MECKLENBURG COUNTY
Park and Recreation Department

MEMORANDUM

DATE: May 21, 2024

RE: Rezoning Petition #2024-029
PID# 02506206

TECHNICAL DATA SHEET

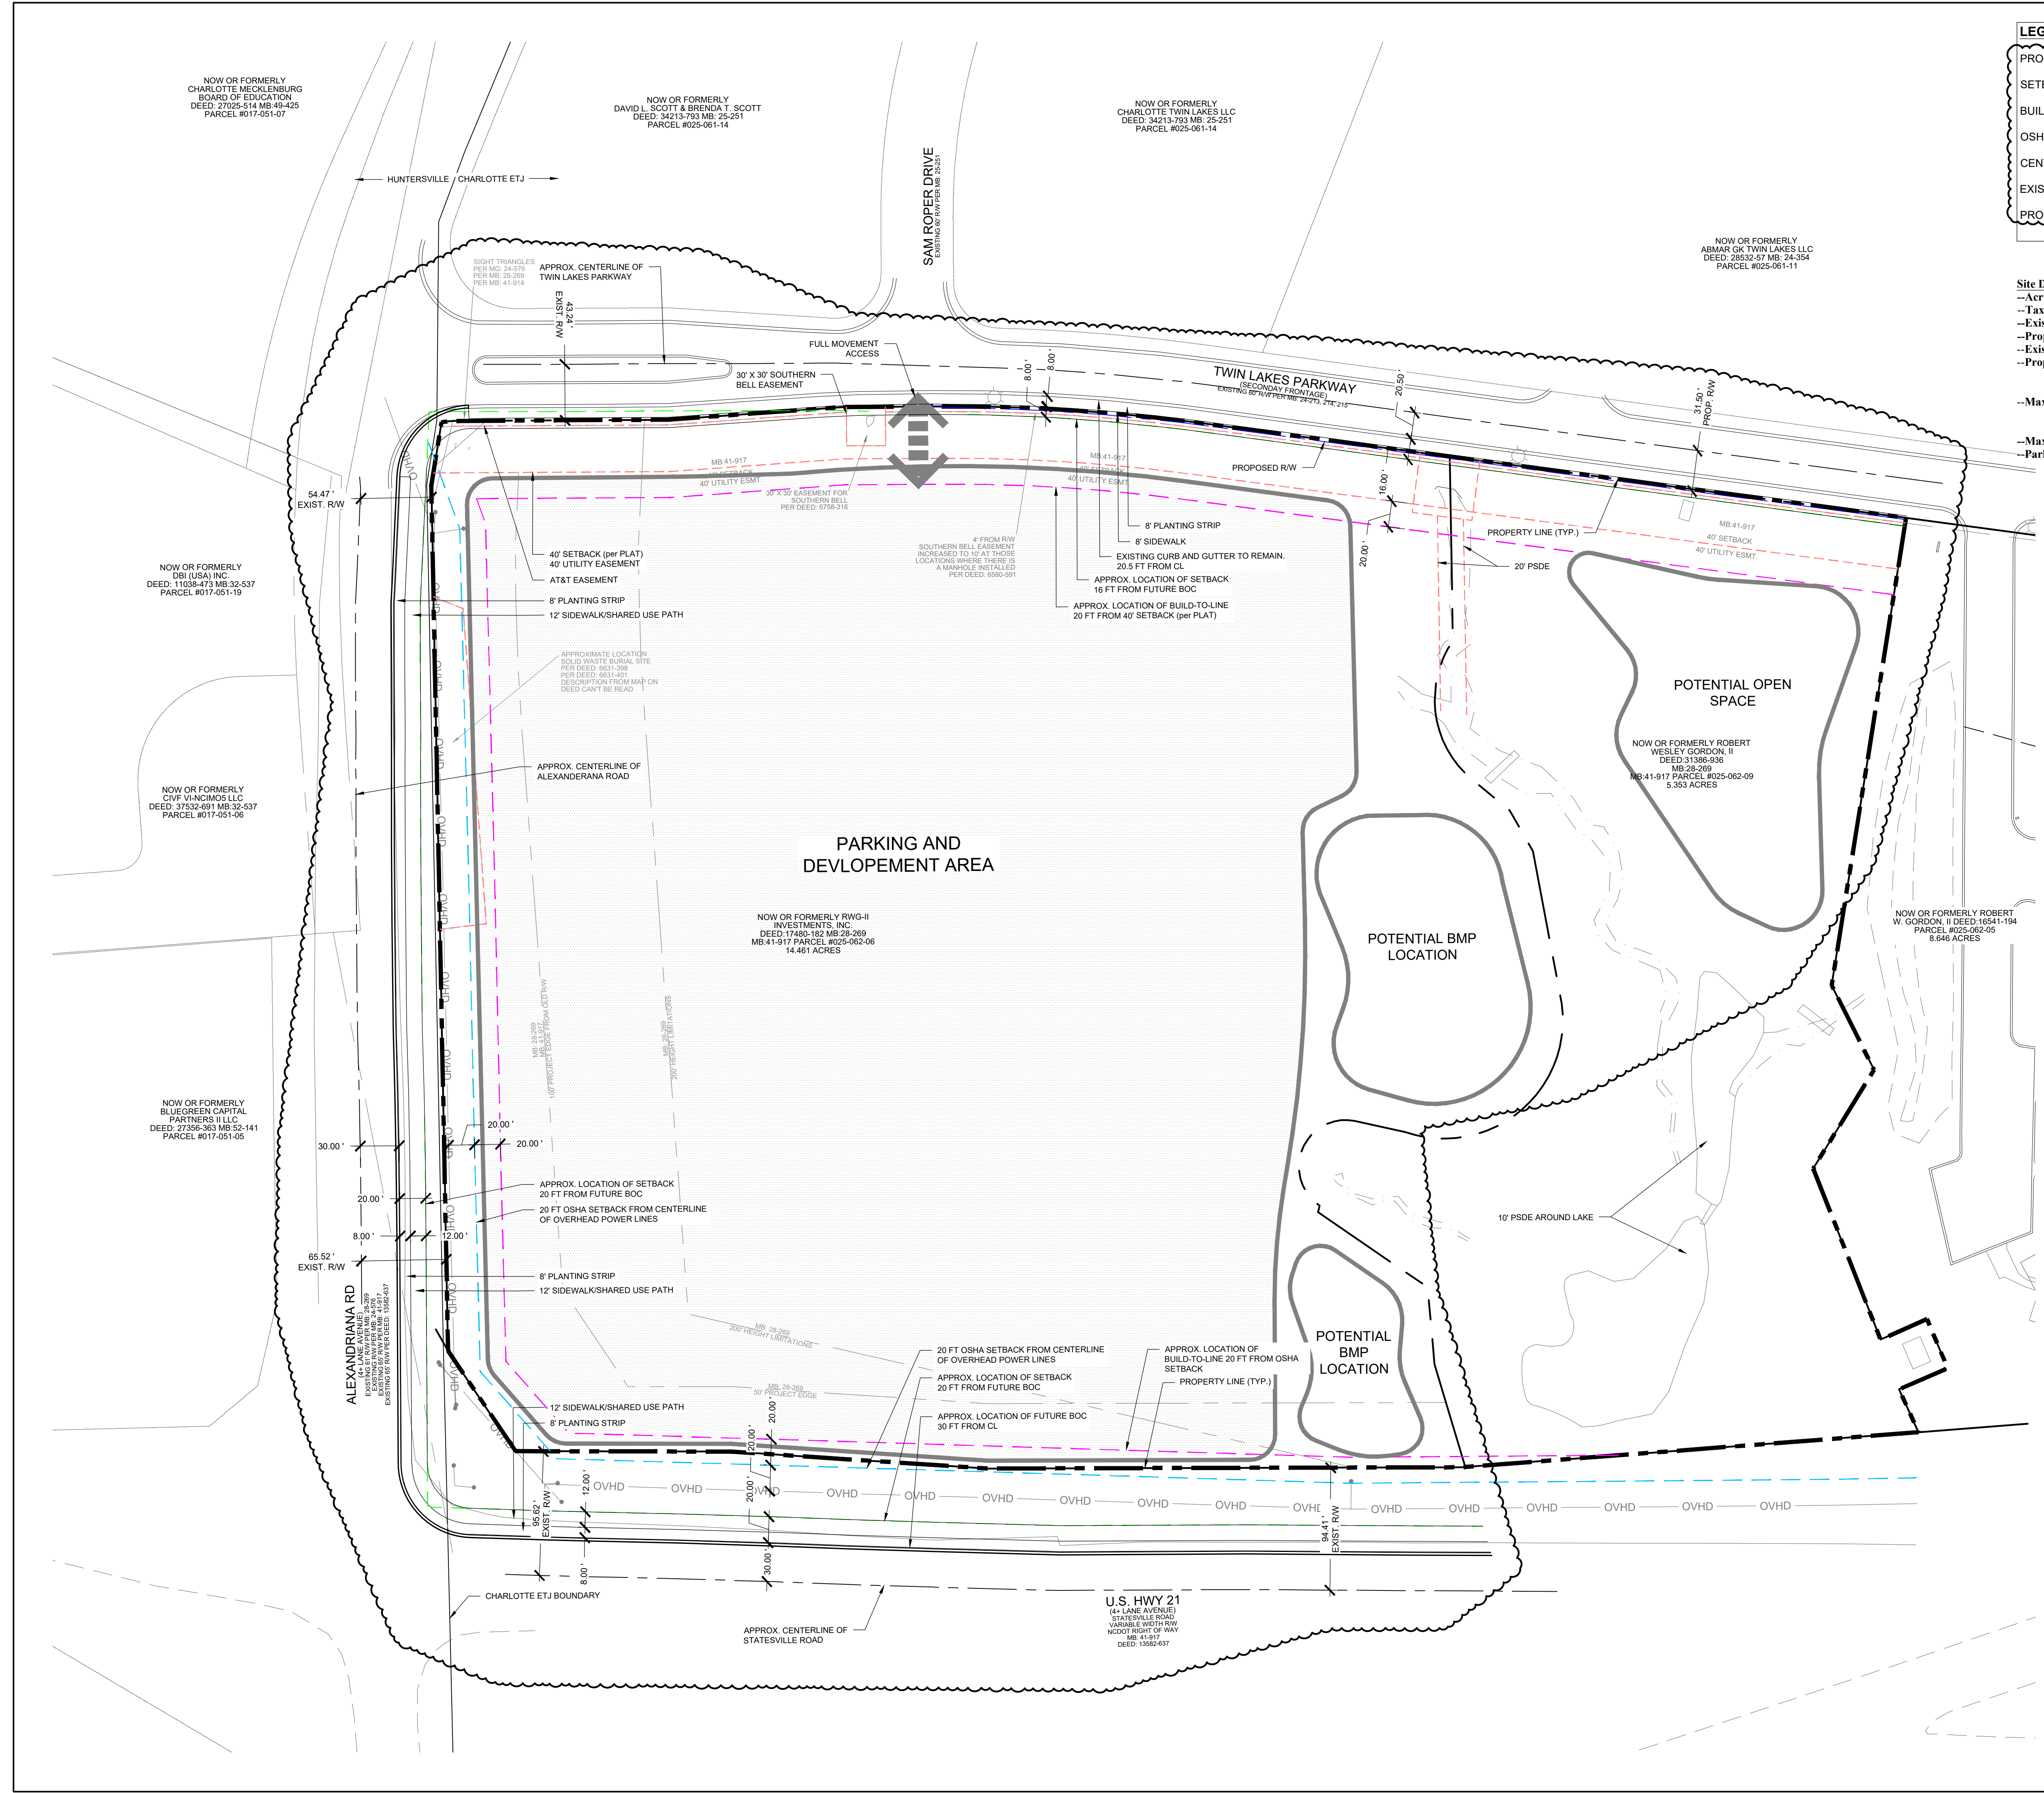
MCPR requests a minimum of **1.0** acres to be dedicated and conveyed to Mecklenburg County for a future neighborhood park. This requested park land shall be adjacent to a public right-of-way for access and is conducive for the development of the typical amenities found in a neighborhood park and cannot include tree save parcels or stormwater BMP's.
